DETERMINATION OF MAJOR PROJECT NO. 06_0301

**ALTERATIONS AND ADDITIONS TO CHATSWOOD CHASE SHOPPING CENTRE
AT 345 VICTORIA AVENUE, 19 HAVILAH STREET AND 8 MALVERN AVENUE,
CHATSWOOD**

RECOMMENDED CONDITIONS OF APPROVAL

A: Plant Platforms
Reduced parapets

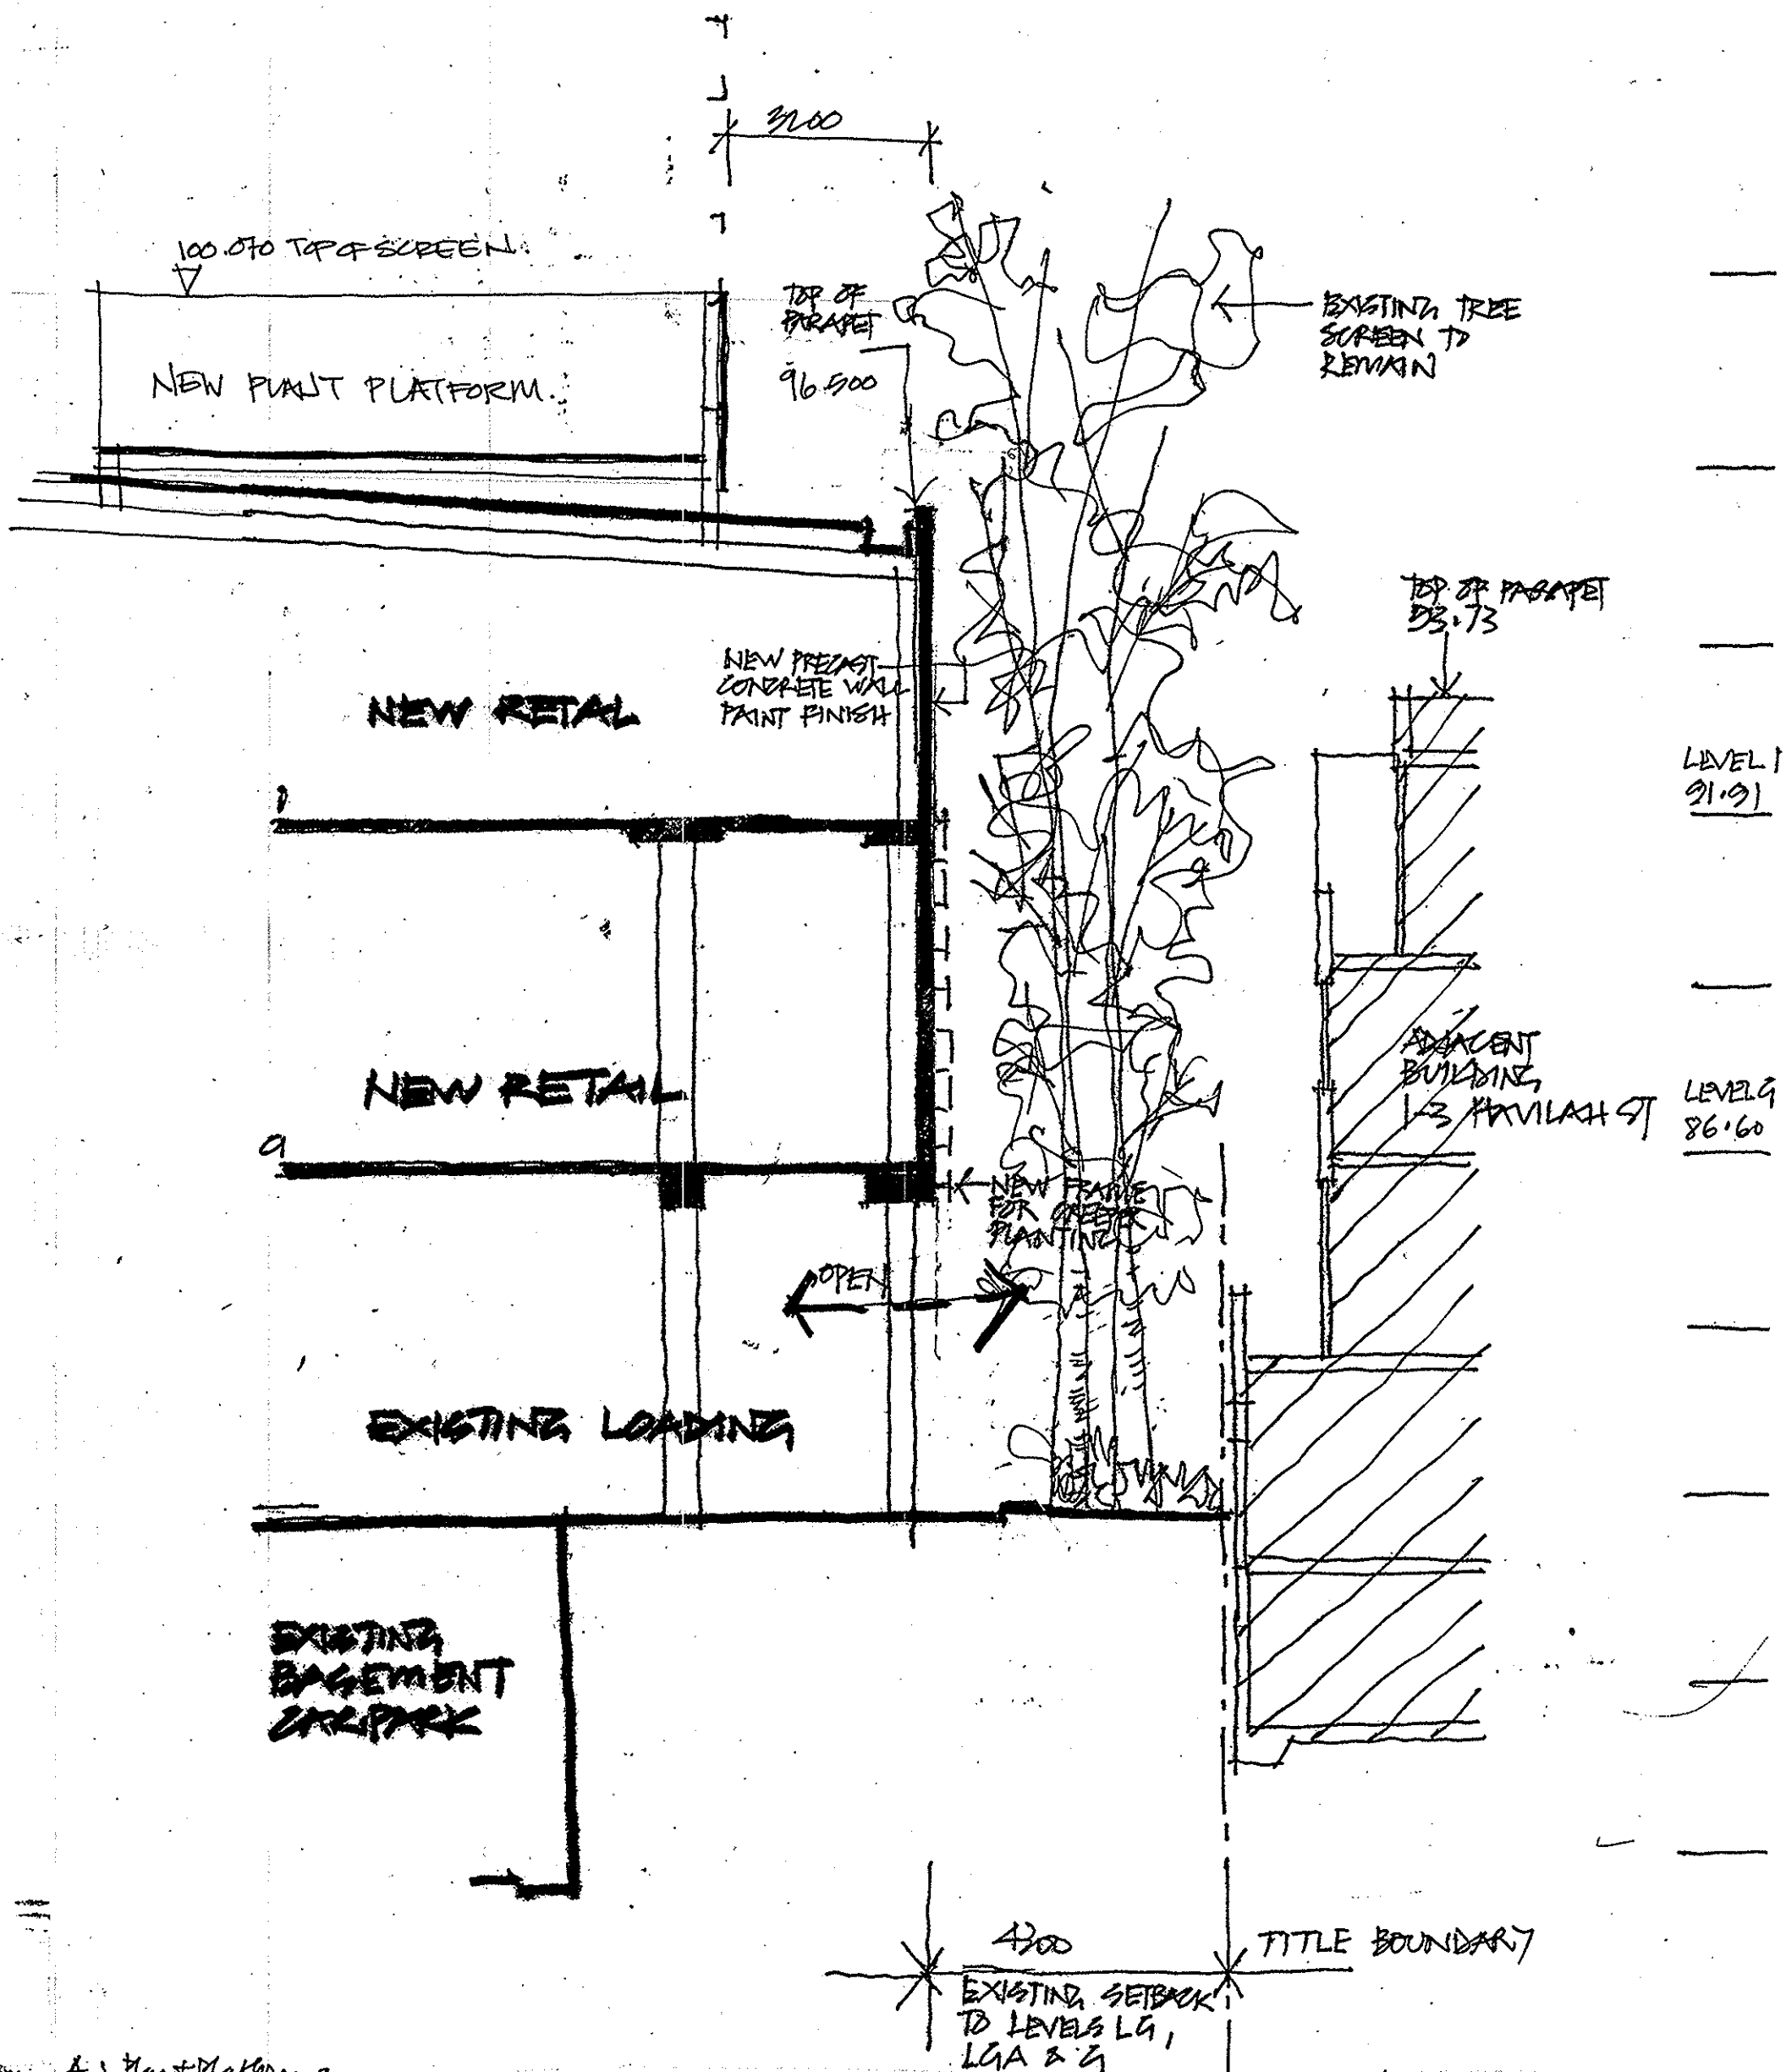
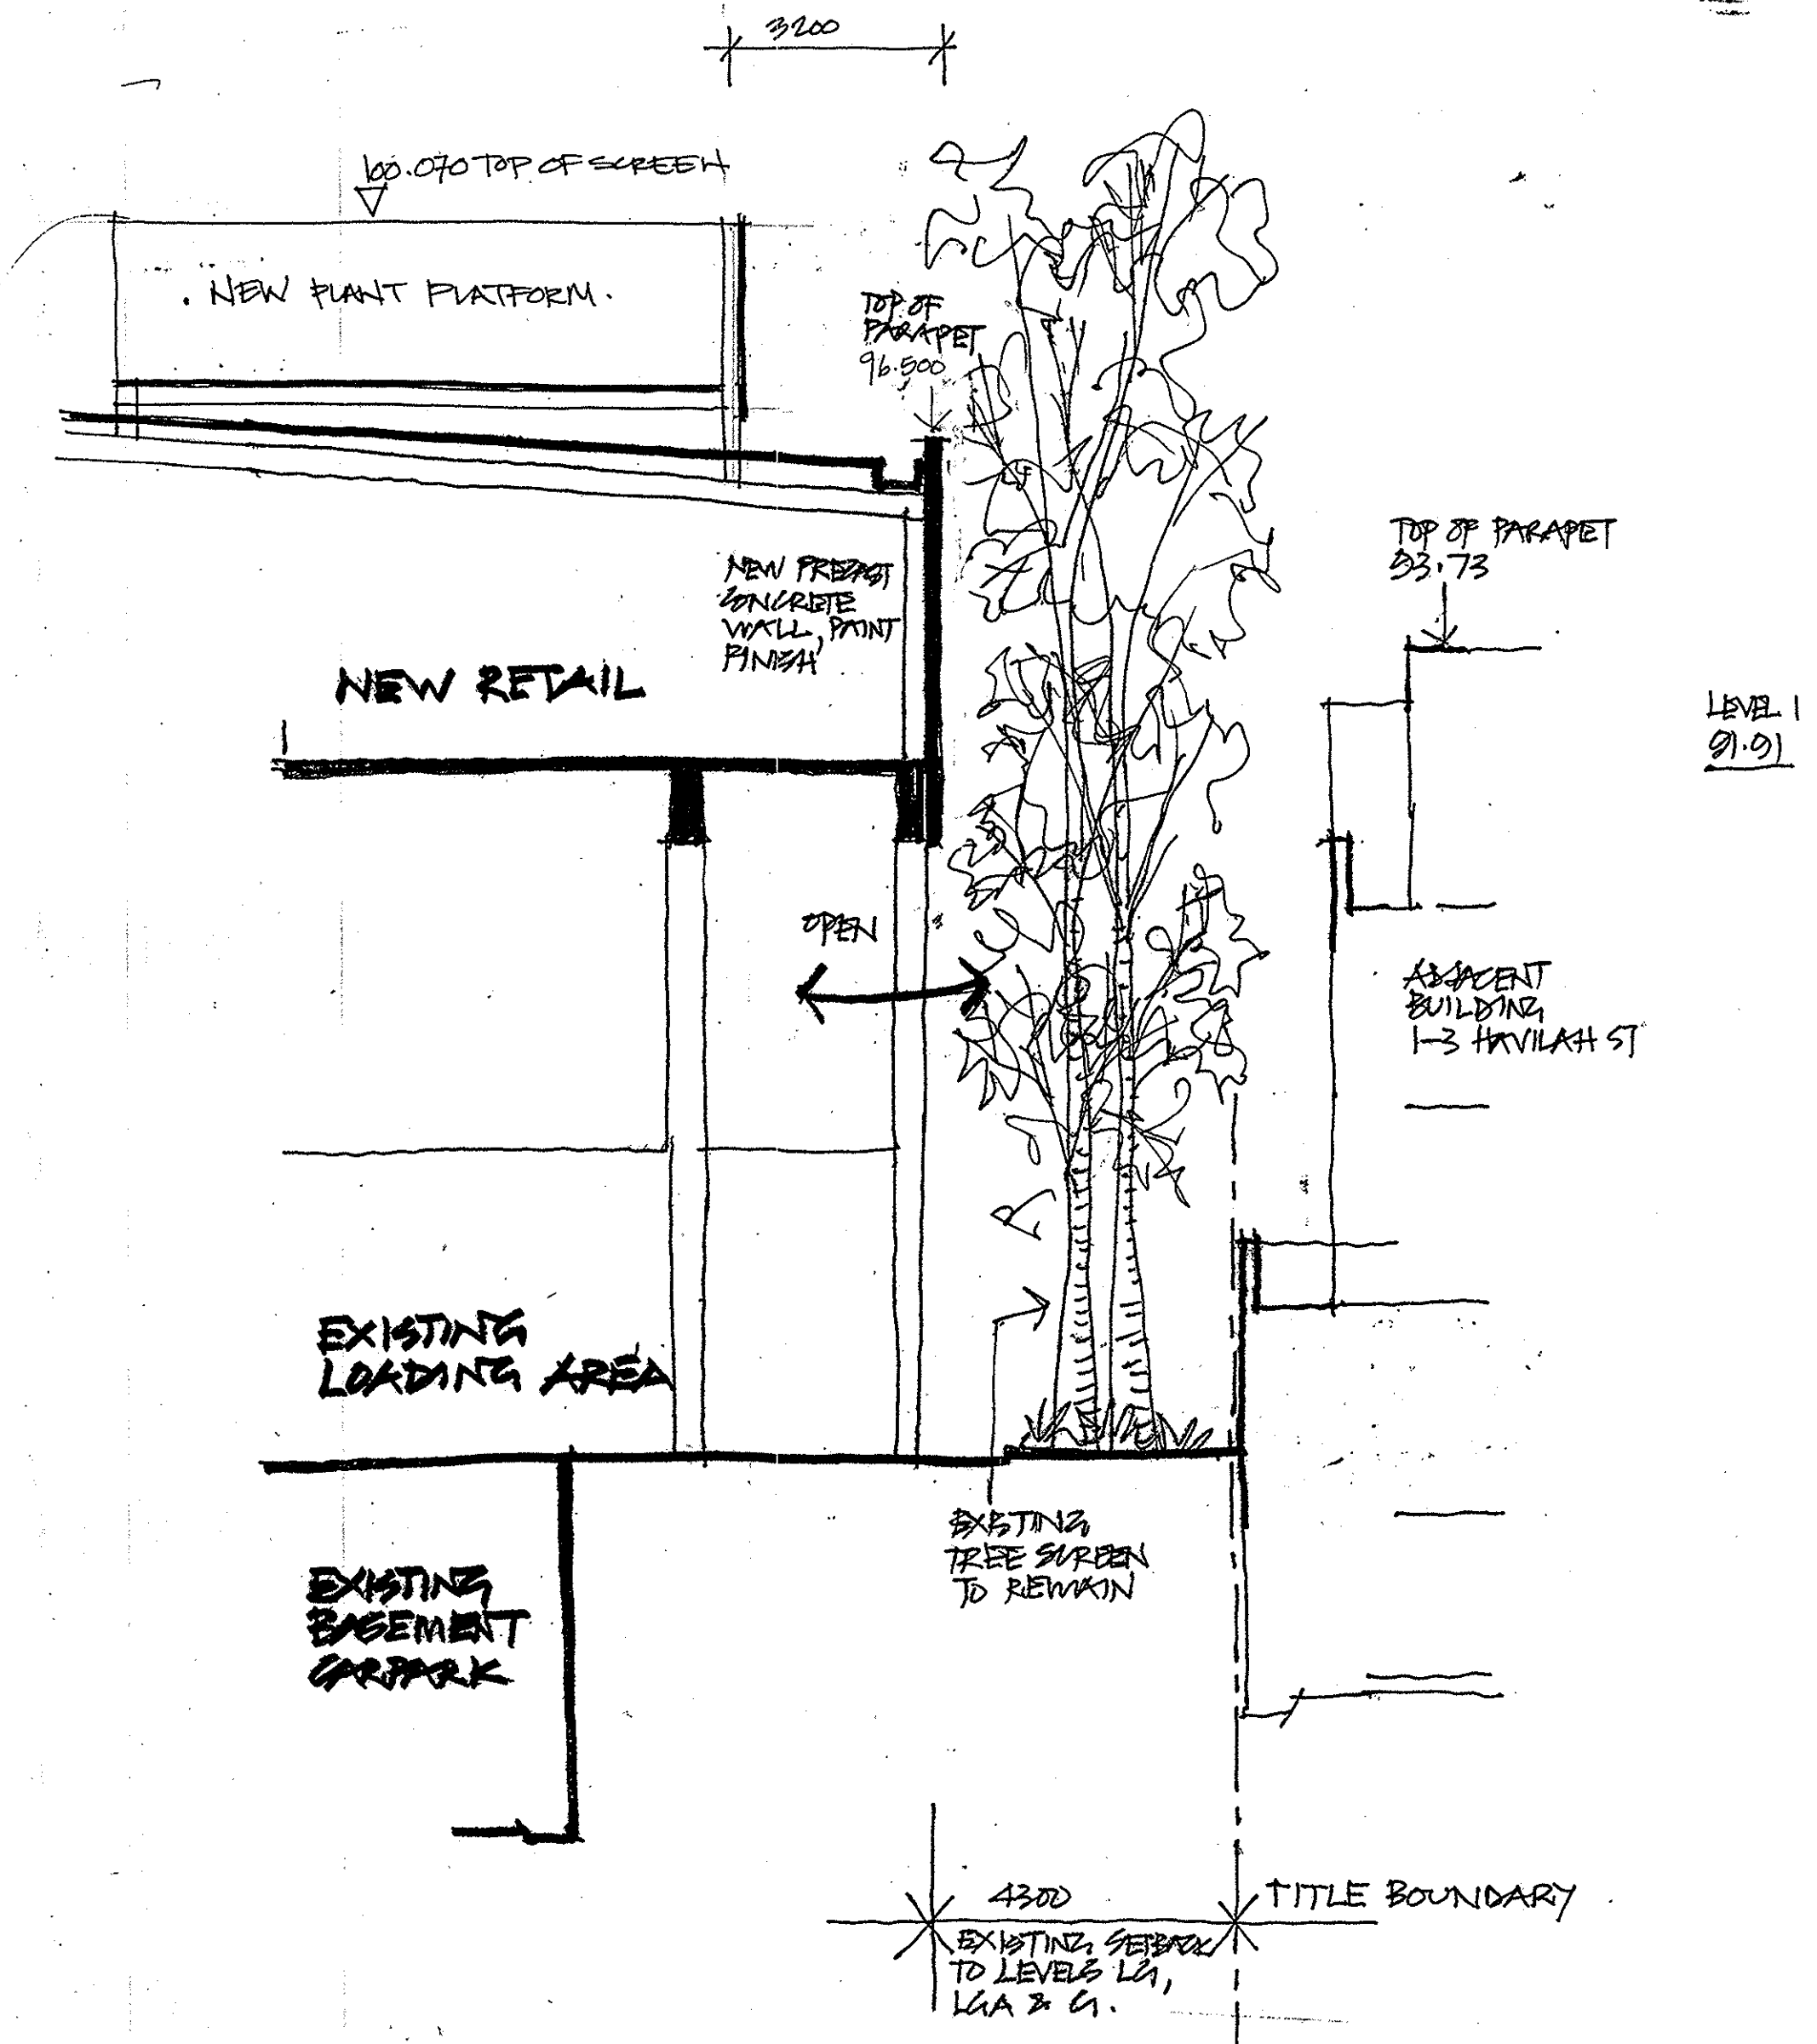
- (1) The location, form and integration of all roof mounted plant rooms and vents has not been sufficiently detailed in the application. Further design information is required that demonstrates that they will be integrated into the roof or building structure as relevant. Roof mounted plant in the vicinity of boundaries shared with neighbours shall be set back at least 3.5 metres from the face of the building. Vents and shafts or similar shall be set back a minimum of 3.5 metres where the building face is adjacent to 1-3 Havilah Street.
